Traffic Engineer's Statement

To: Elizabeth Nijkamp
Engineer Manager, El Paso County

Re: **Vantage Homes Storage: Traffic Memorandum
El Paso County, CO**

Site Plan

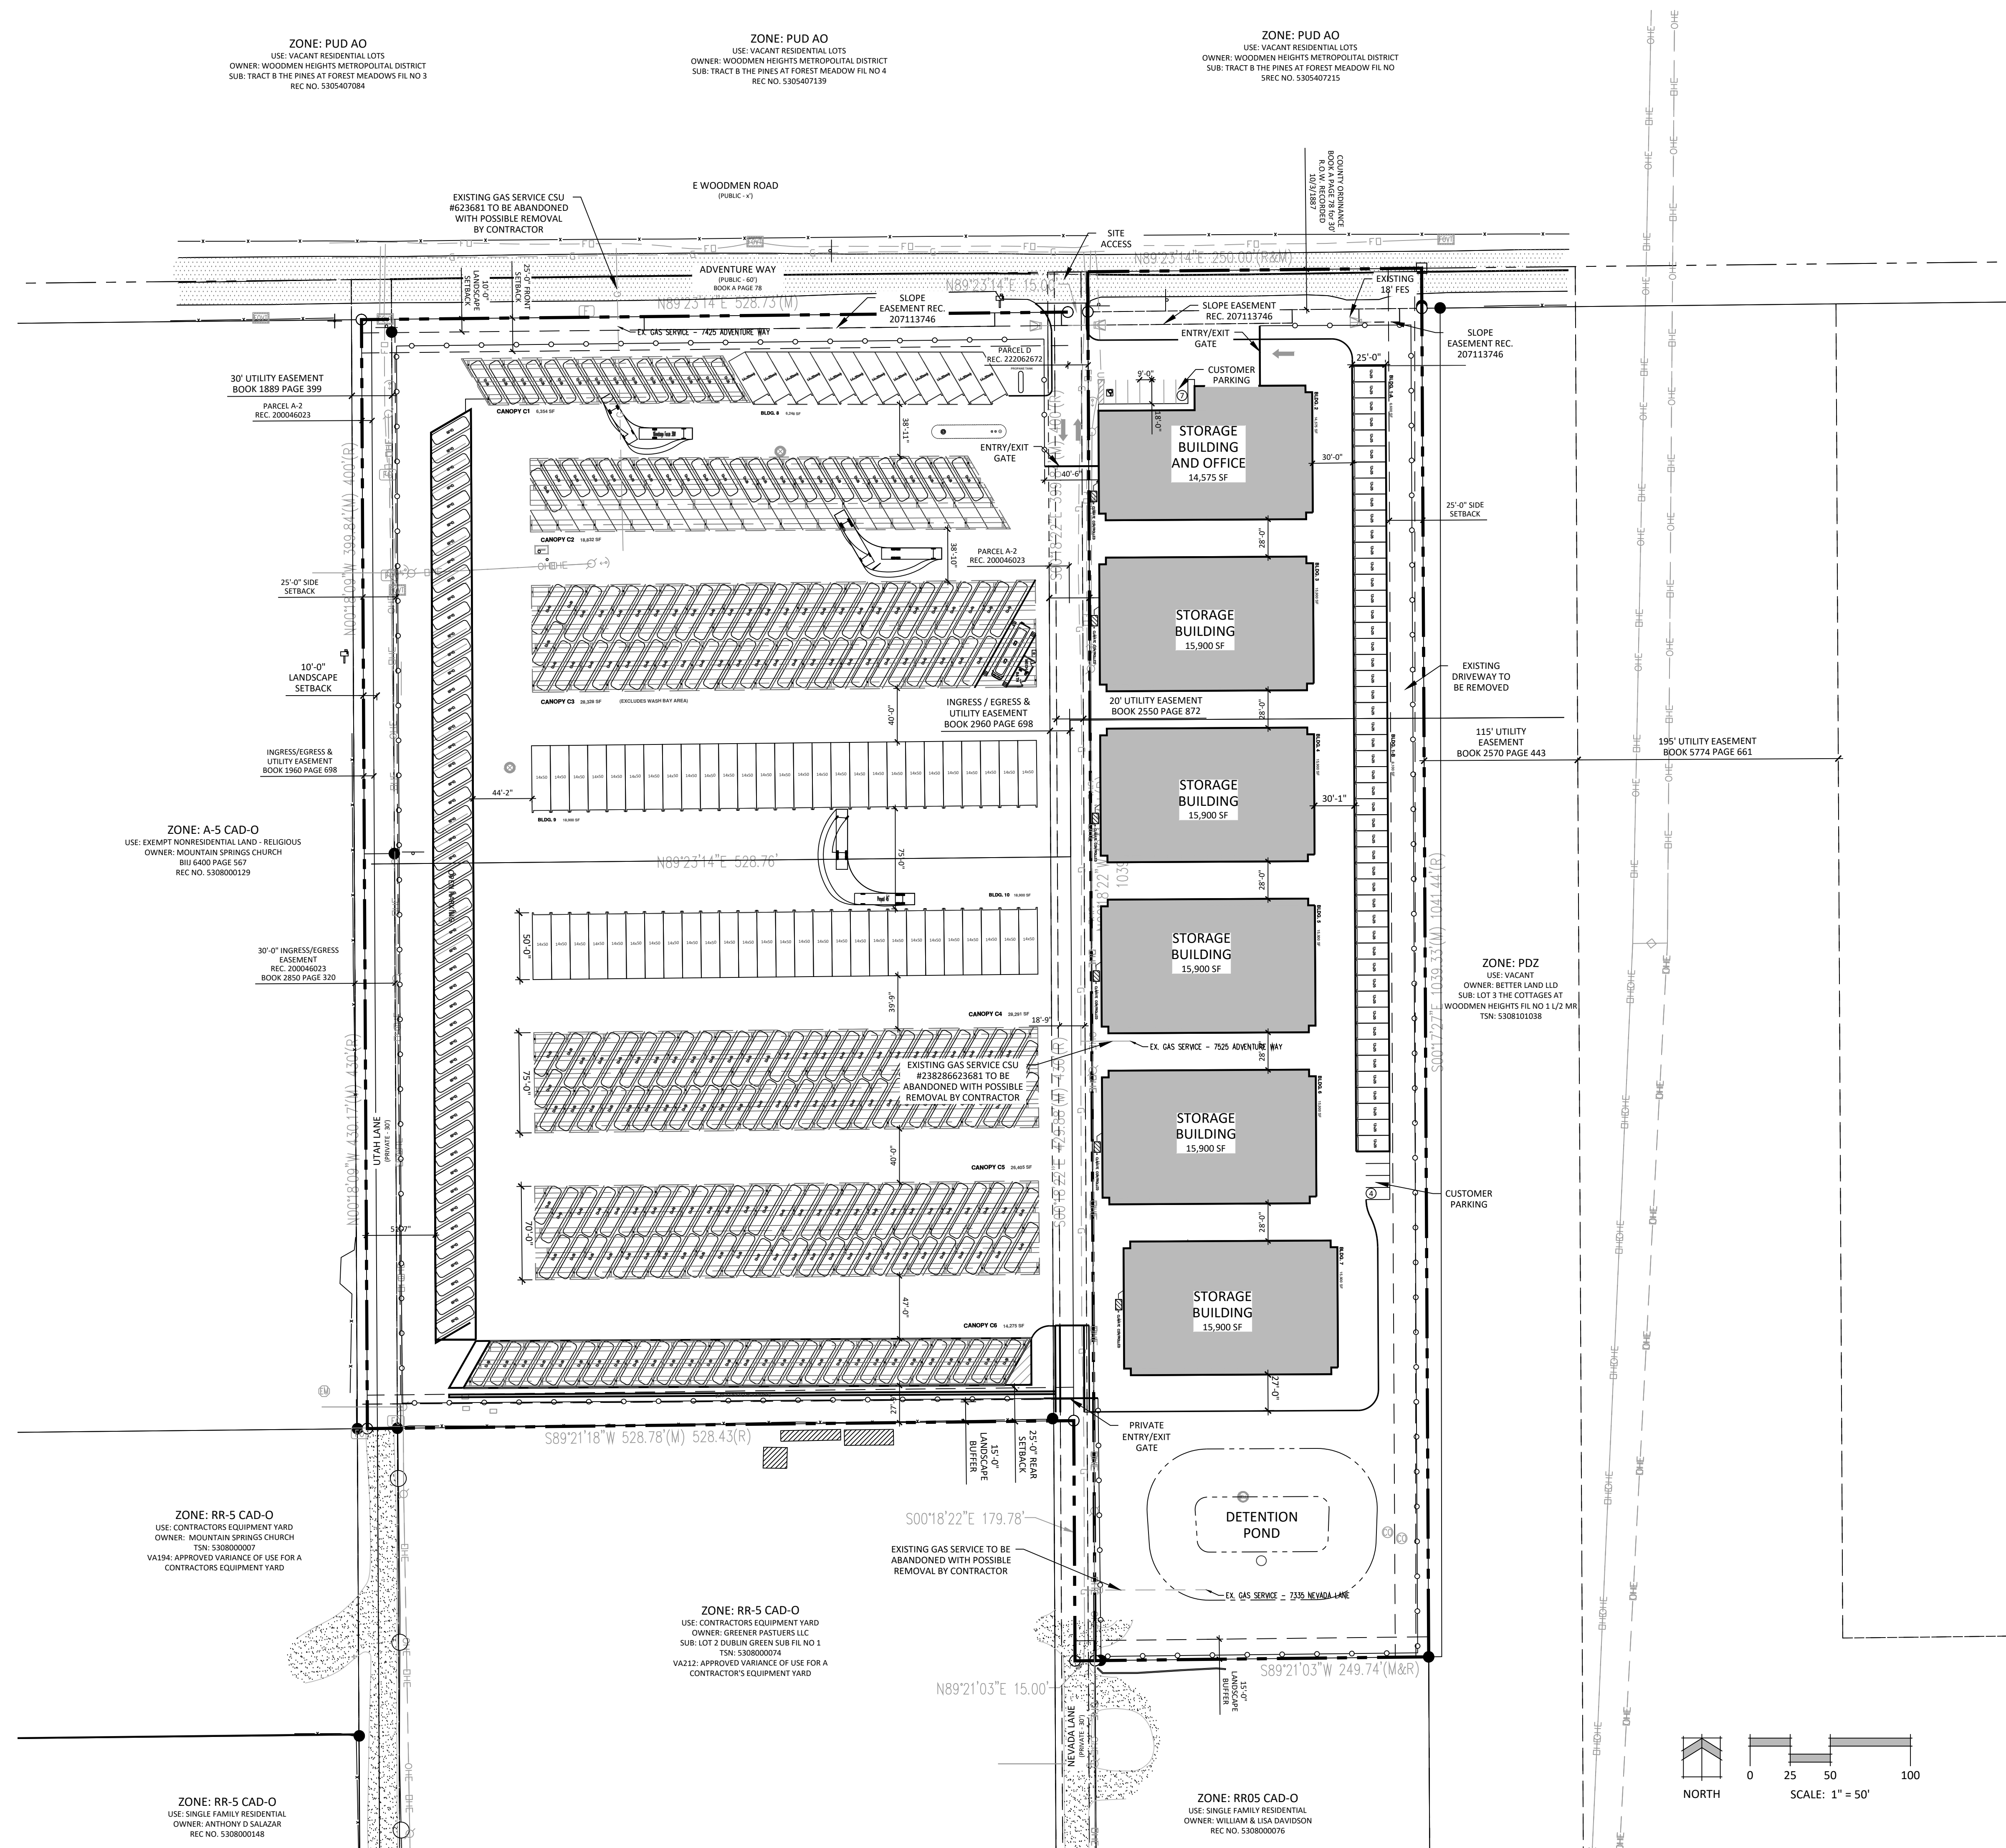
Please review the project manager's comments about installing two gates to close Nevada Lane.
